Item No. **Report of the Head of Planning, Transportation and Regeneration**

Address 41 TOLLGATE DRIVE HAYES

Development: Single storey rear extension

LBH Ref Nos: **67932/APP/2021/2437**

Proposed Ground Floor Plan

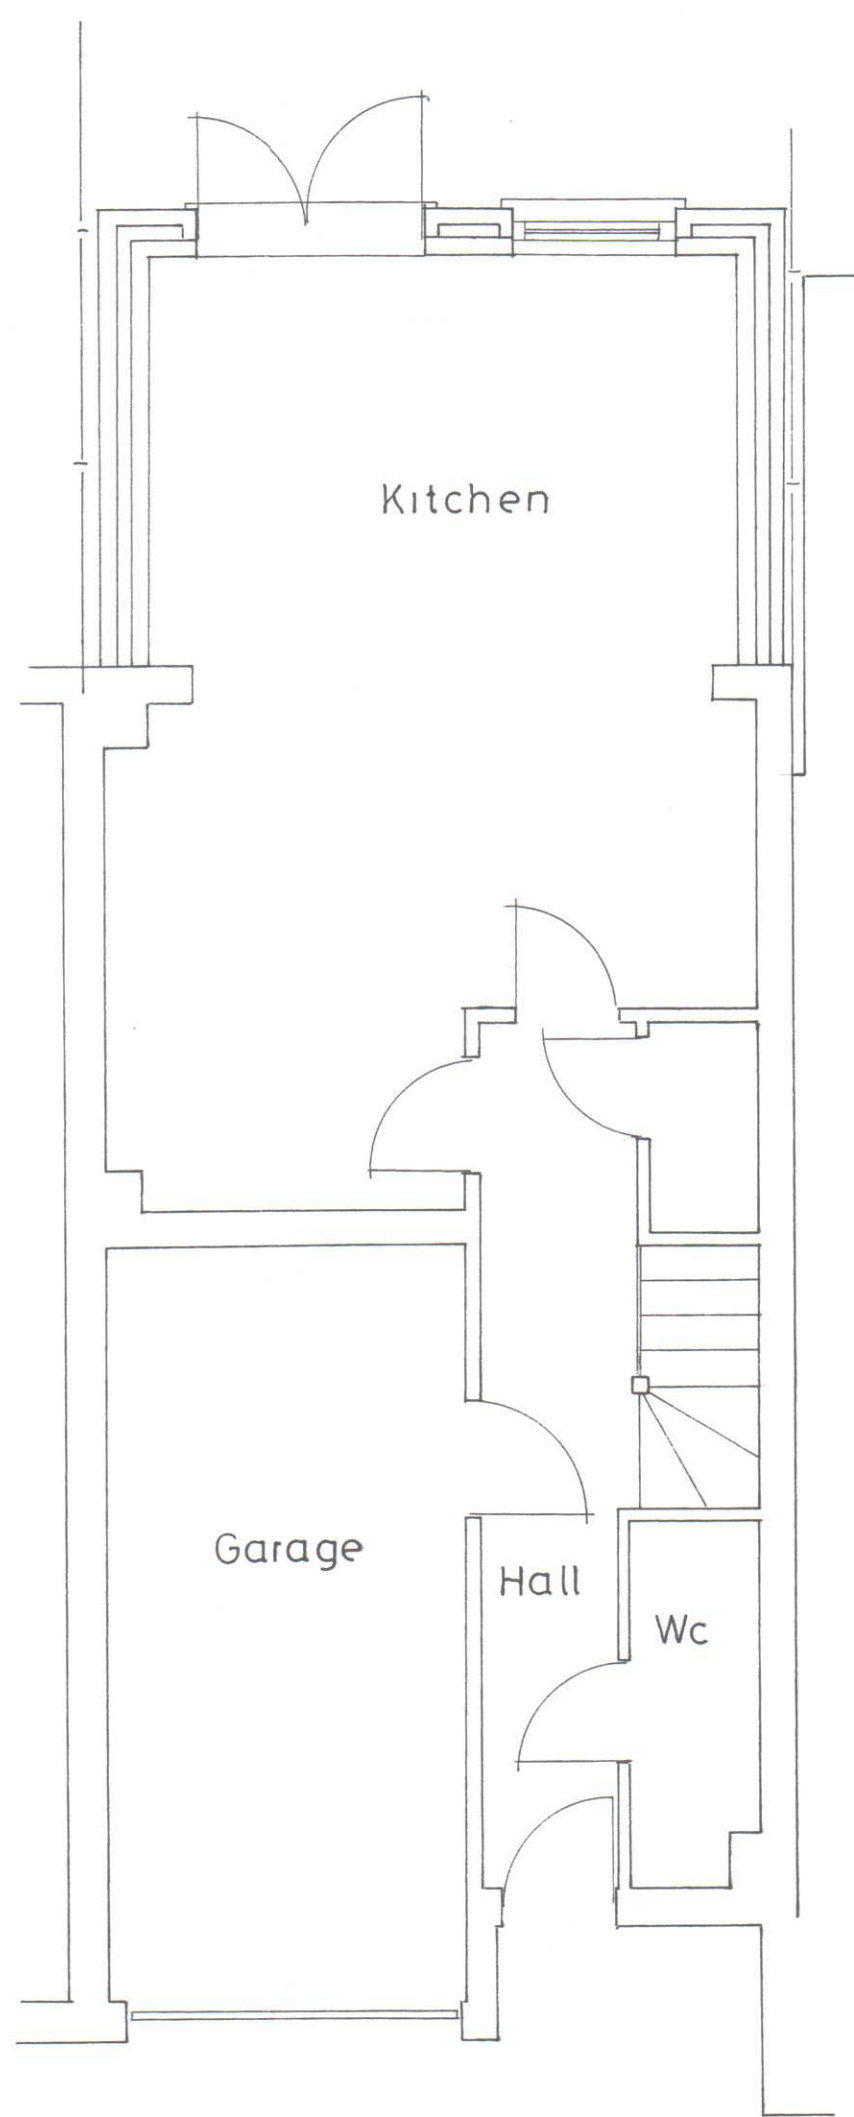
The proposed development would result in only approximately 40 square metres of private amenity space. The limited rear garden area which would remain would be insufficient to serve a dwelling of this size, and would fall significantly short of what is typically required by Table 5.3: Private Outdoor Amenity Space Standards of the Hillingdon Local Plan: Part Two - Development Management Policies (2020). Whilst it is acknowledged that the existing rear garden measures approximately 55 square metres, the proposed development would worsen the situation for the occupiers at the site, especially given the fact that the number of bedrooms and thus potential occupiers, is increasing. The proposal would leave them with an unacceptably small area of private outdoor space. It is considered that the benefits that would be derived from the additional living space would not outweigh this harm.

Having regard to the above considerations, it is considered that the proposal would unacceptably undermine the provision of private amenity space at the site, and would limit the opportunity for general outdoor activity that occupants could reasonably expect with a property of this size and type. The proposal would therefore fail to comply with Policies DMHD 1, DMHB 11 and DMHB 18 of the Hillingdon Local Plan: Part Two - Development Management Policies (2020), in this respect.
